From: Maria Tomalova <Maria.Tomalova@arun.gov.uk>
Sent: 12 December 2019 10:24
To: Planning.Responses <Planning.Responses@arun.gov.uk>
Subject: FW: AW/232/19/OUT, 19 & 21 Nyewood Lane

From: stephen jupp [REDACTED]
Sent: 16 September 2019 07:29
To: Maria Tomalova [REDACTED]
Subject: Re: AW/232/19/OUT, 19 & 21 Nyewood Lane

Please find below the comments of WSCC on your proposal:

DRAWN BY		DATE		SCALE		SHEET NO.	
P. BRESNAHAN	K. RICHARDS	19 - 21 NYEWOOD LANE	ILLUSTRATIVE	1:100	A2	5	5
PROJECT NAME		SITE PLAN		DATE		SHEET NO.	
19 - 21 NYEWOOD LANE		ILLUSTRATIVE		DATE		SHEET NO.	
BROOKING RECS		SITE PLAN		DATE		SHEET NO.	
06.08.2019		1:100		A2		5

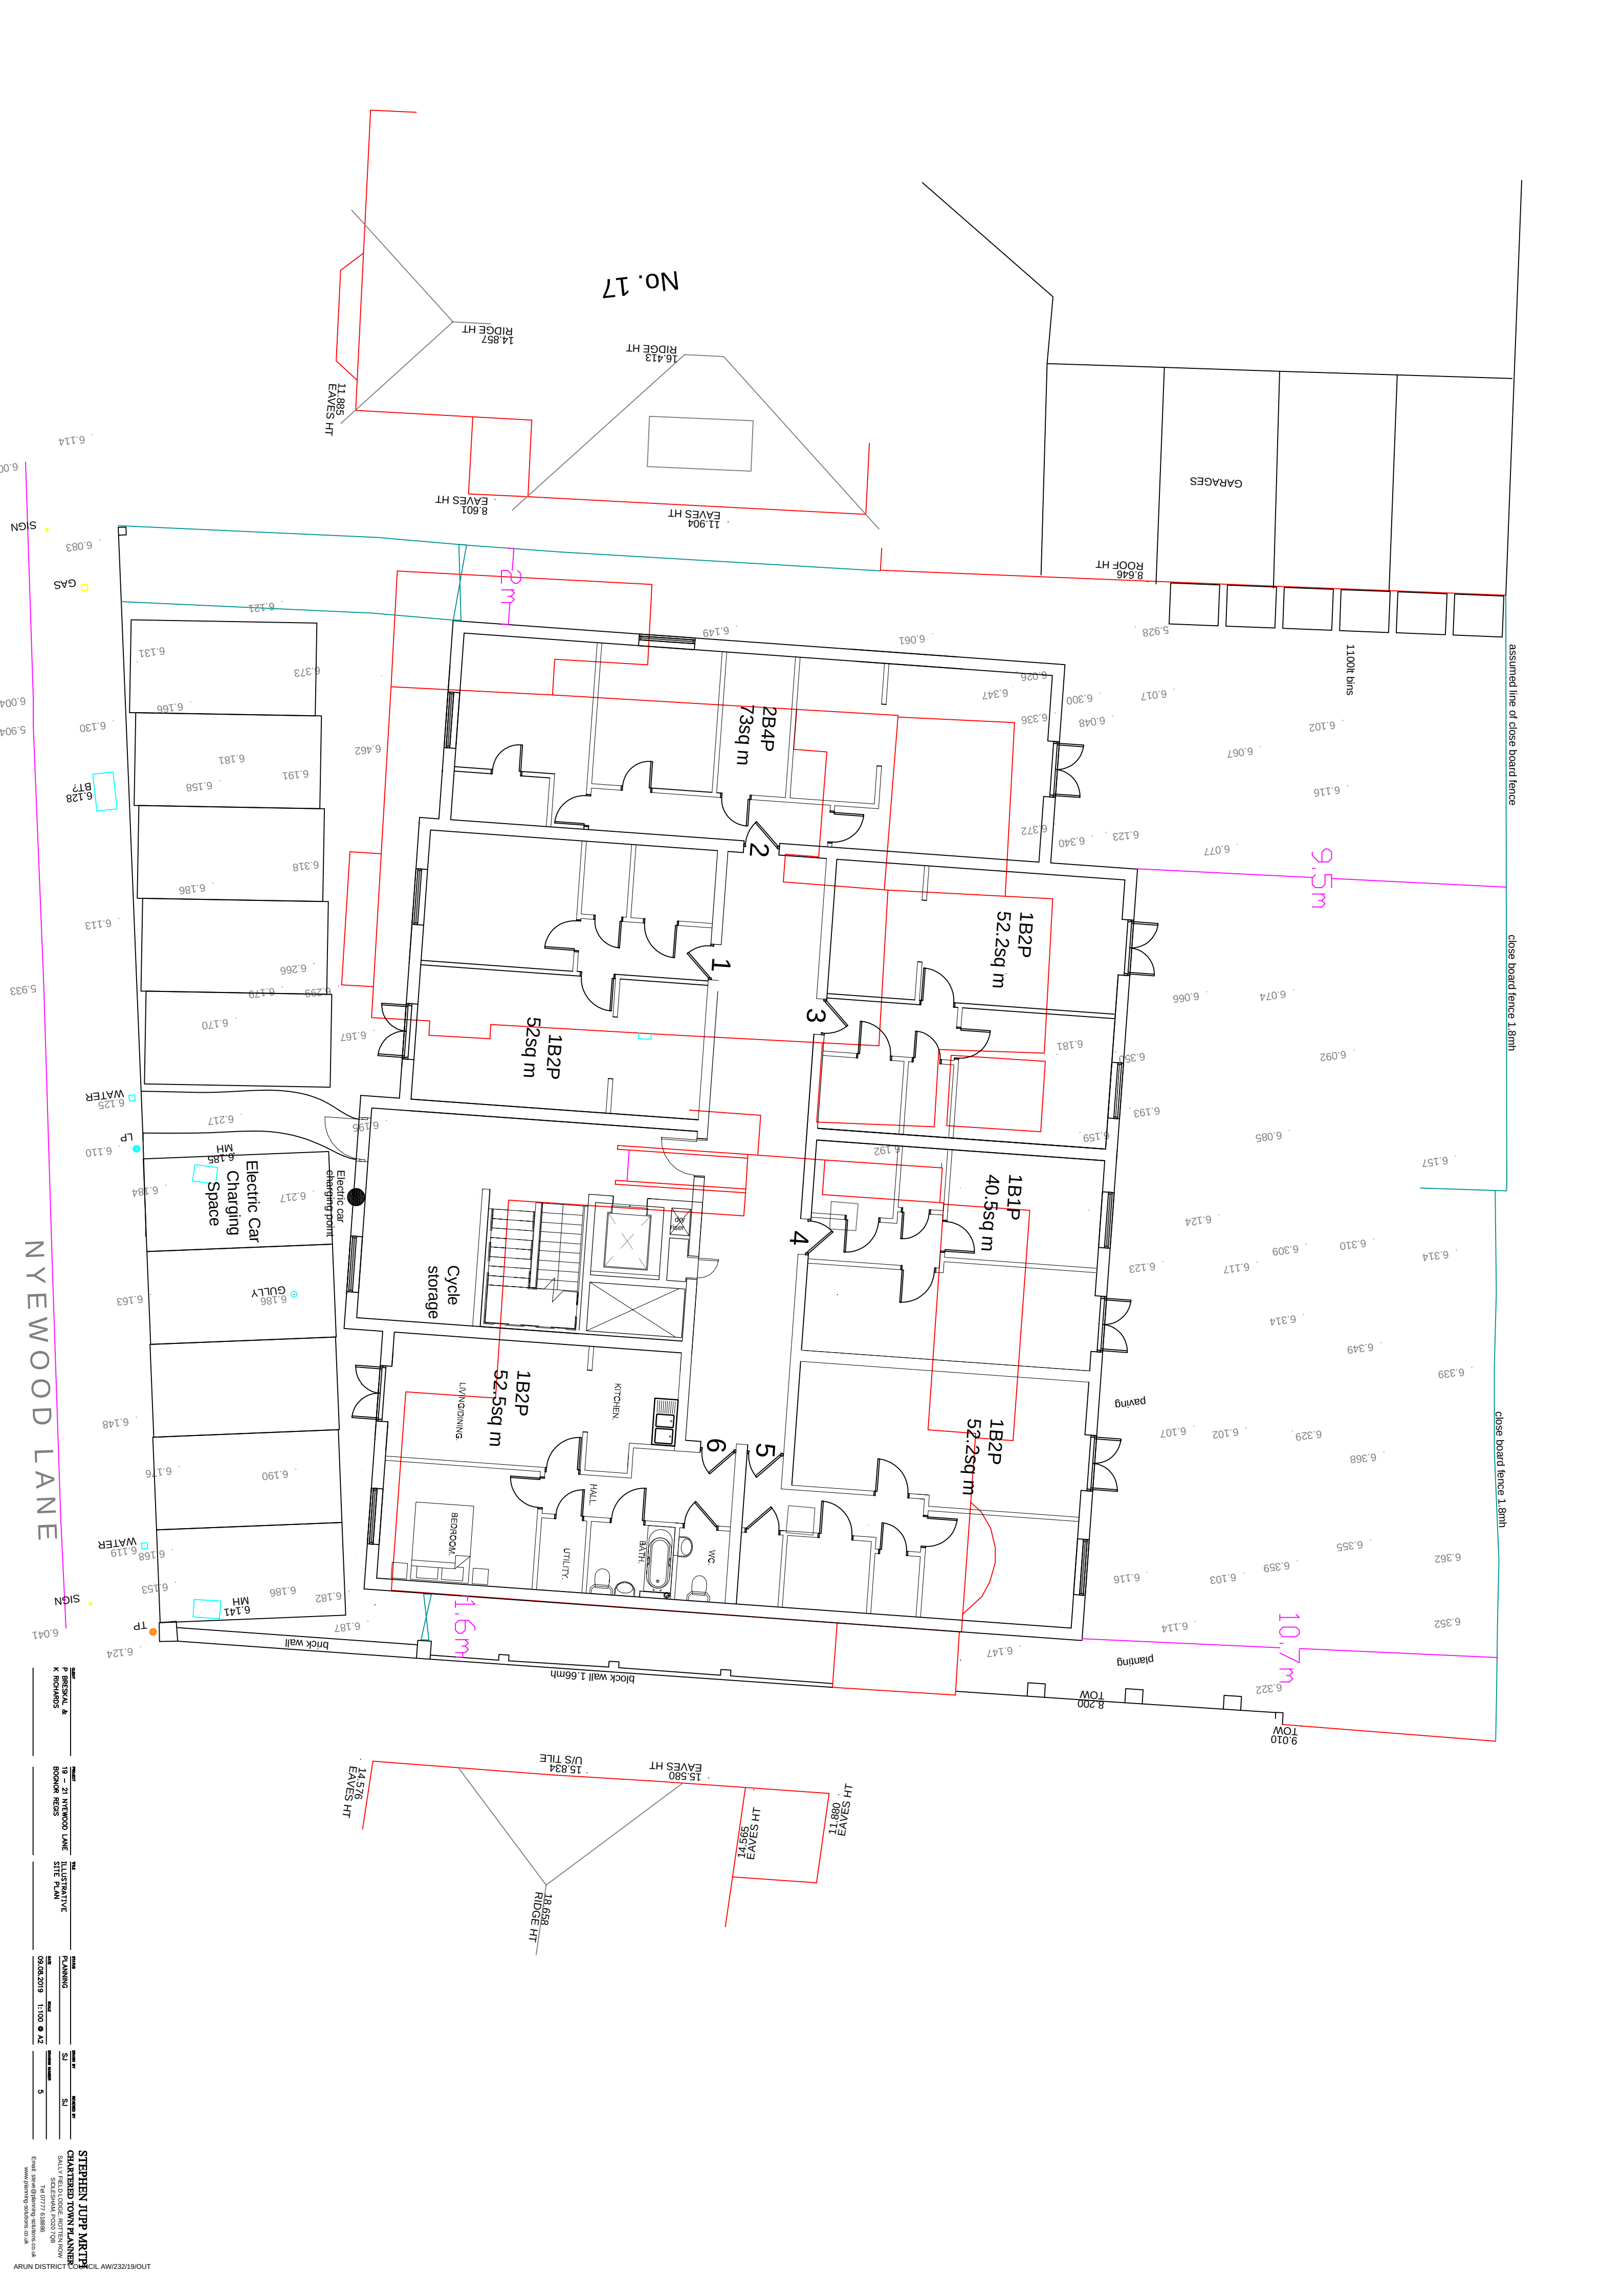
Point 4.18 of Planning Statement refers to access being via established point on to Victoria Drive, however the site fronts on to Nyewood Lane. There is an existing level of off-street frontage parking at the site and from an inspection of local and WSCC mapping

there does not appear to be a visibility issue on to Nyewood Lane and there is no evidence that the existing dropped kerb vehicle access has been operating unsafely. Whilst no extensions to existing dropped kerb are proposed, it does appear that this may

be required to provide access to all 10 x off-street parking spaces. Furthermore, it is unclear whether access to northern and southern most spaces would require passing through on-street parking bays and thus through a Car Parking Zone (CPZ). If so then an

alteration to the existing Traffic Regulation Order (TRO) may be required. Plans should clearly indicate extent of dropped kerb required and whether proposed parking spaces are adjacent to on-street parking bays.

The site plan indicates 10 x parking spaces off the road (on frontage of site). One space will be provided with electric vehicle charging point. The Planning Statement outlines that 1 space per 2 flats will therefore be available. The applicant should clarify whether any spaces will be allocated or will be provided on a first come first serve basis.

in response to the comments of WSCC Highways, this application is in outline form with ALL matters reserved so i accept that they will be some lack of detail on highway matters.

I accept that para 4.18 is wrong and that access will be to Nyewood Lane

If the present scheme were to come forward to reserved matters then a TRO would be required for 2 spaces, but this is something which would be dealt with at that time and it maybe that the layout would be altered in order to avoid the need for a TRO.

It is anticipated that spaces would be allocated, but again this is something for reserved matters stage.
